PRE-HEARING STAFF ANALYSIS

Rezoning Petition No. 2008-084

Petitioner: Pegasus Tower Company, LTD.

Request: INST (CD) SPA, institutional conditional district site plan amendment

SHEET TITLE:
**OVERALL
CONDITIONAL
DEV'T PLAN**

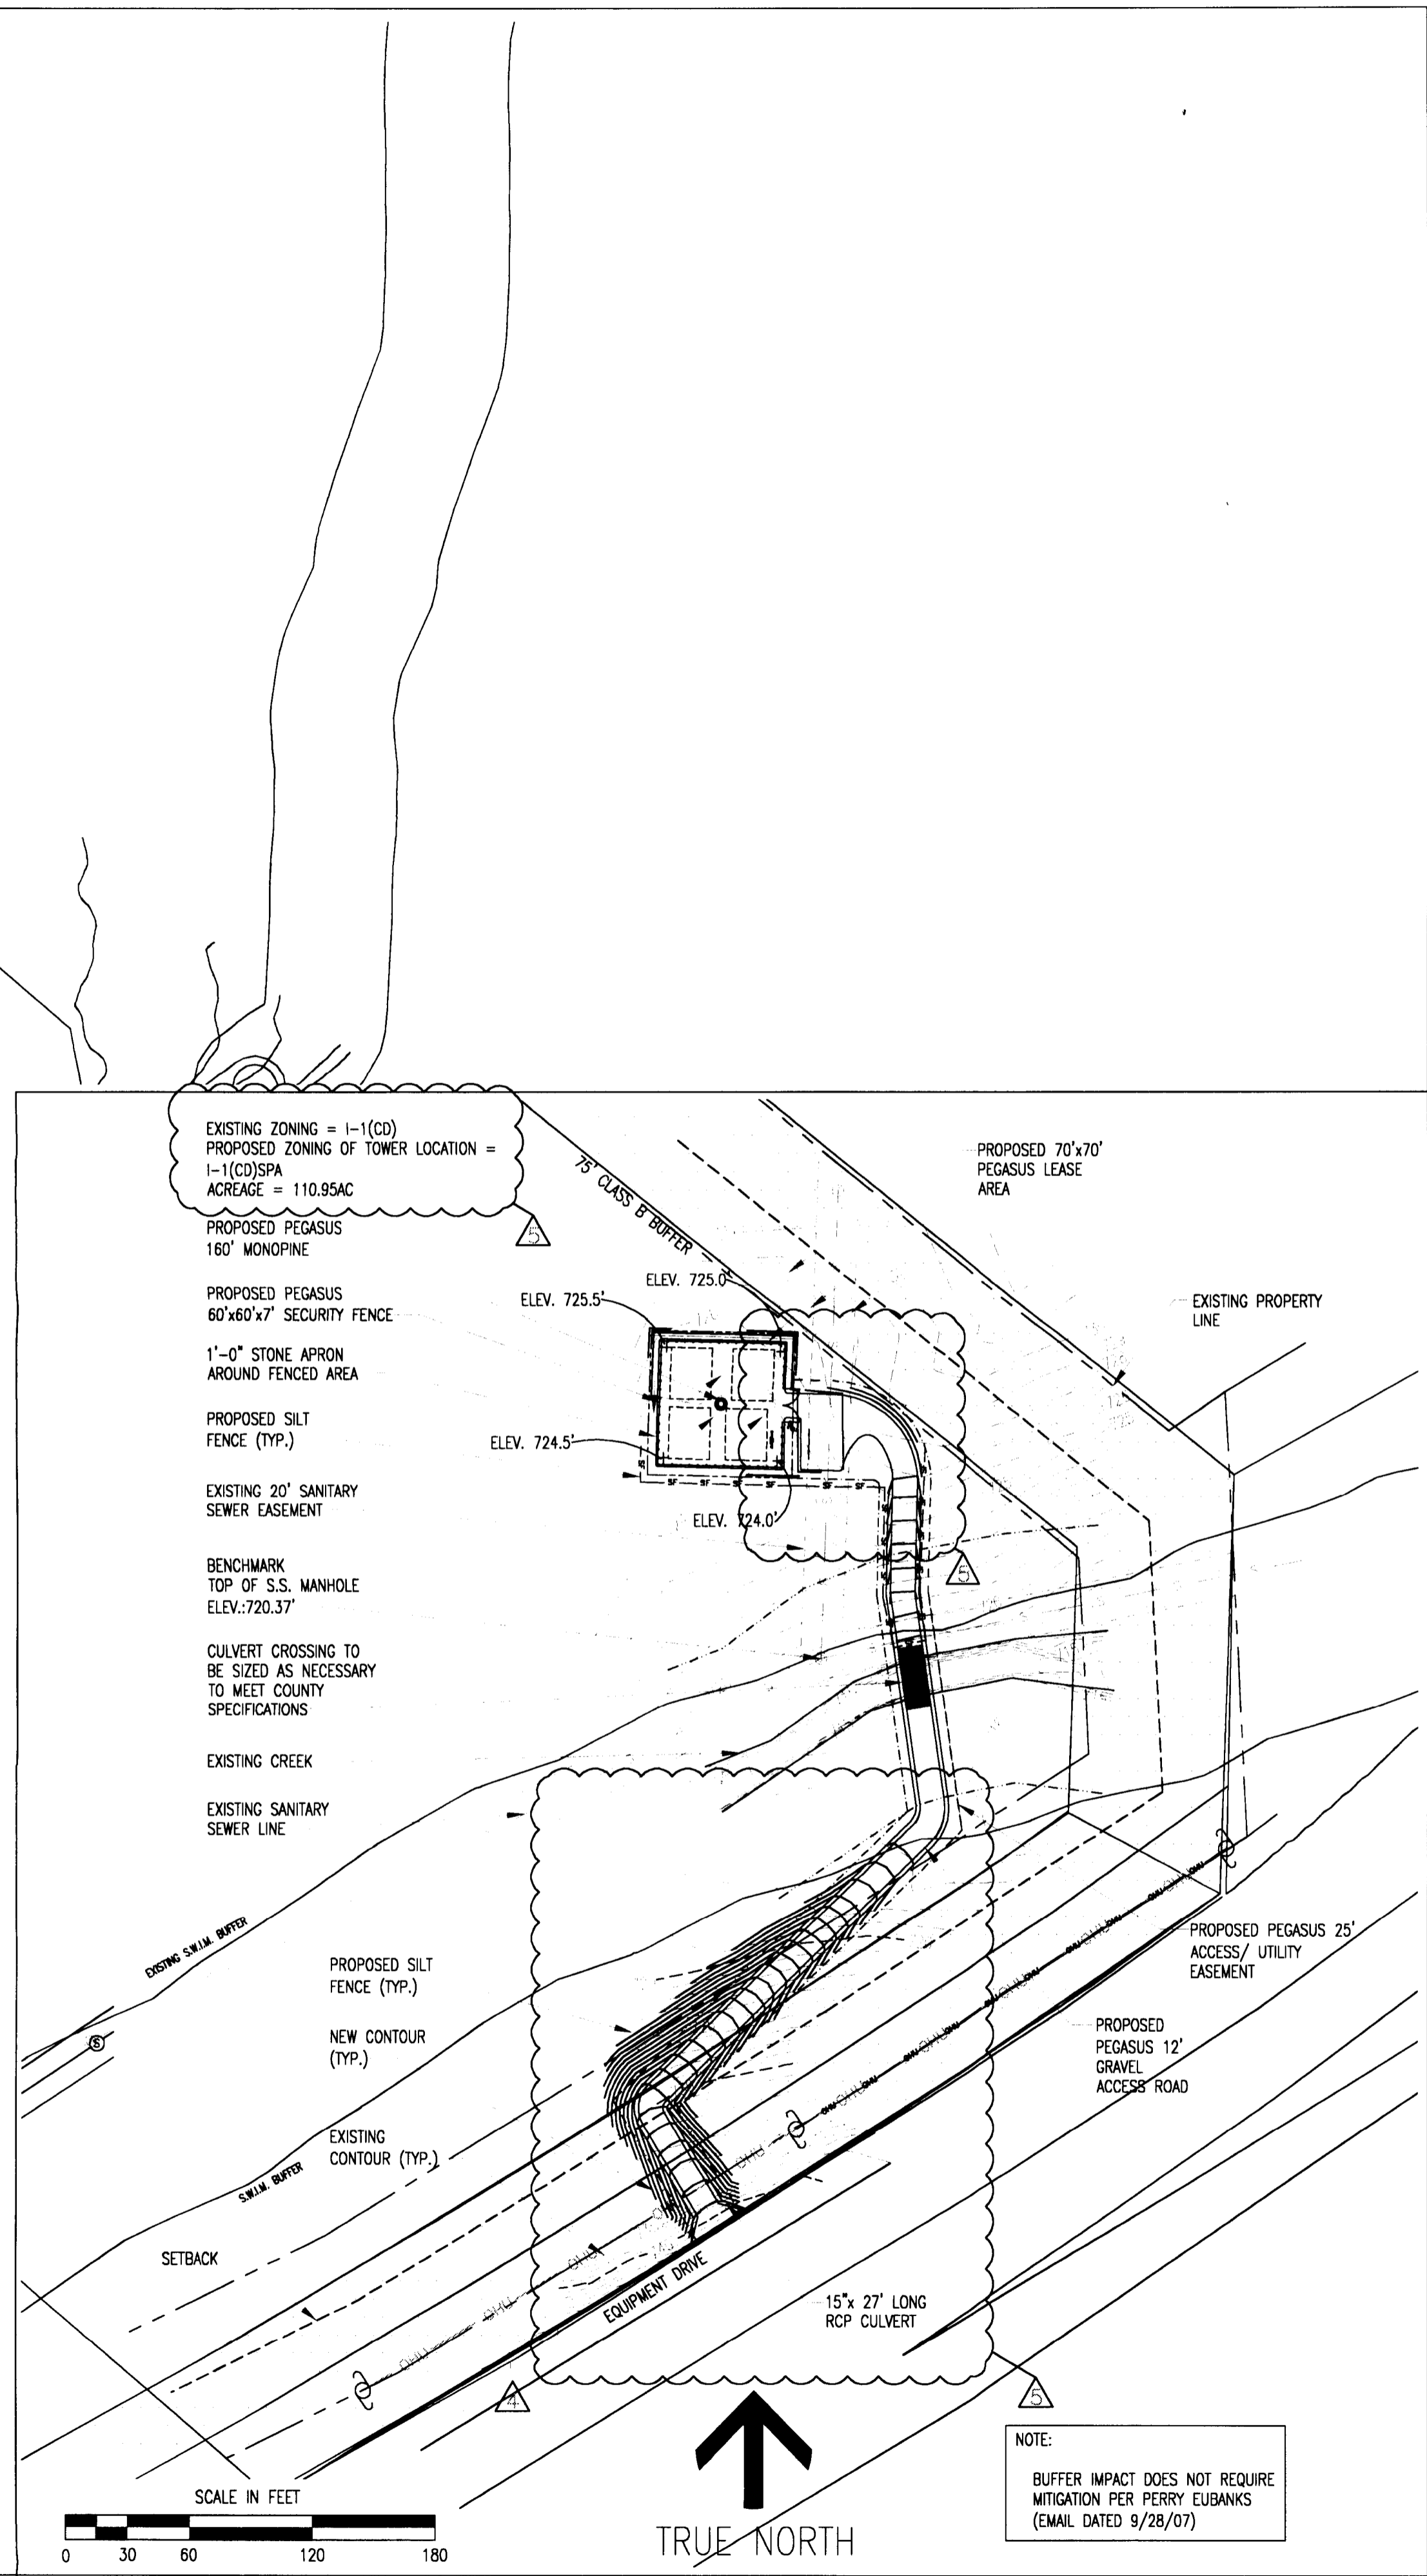
The driveway needs to intersect Equipment Drive perpendicular and not at a skew as shown.

LUESA. A stream segment located on the subject property drains greater than or equal to 300 acres and less than 640 acres. According to the City of Charlotte Zoning Ordinance, Chapter 12, Part 8-Surface Water Improvement and Management (S.W.I.M.) Stream Buffers, Section 12.804, *Buffer Standards*, streams meeting this criterion are required to have buffers 50 feet in width on both sides of the stream measured from the top of the bank.

The site plan should include site development notes showing:

- the existing zoning;
- the proposed zoning;
- the acreage;
- the type of tower;
- proposed height;
- number of carriers the tower will accommodate (minimum of three required by ordinance); and,
- the concealment standards of Section 12.108(8) (j).
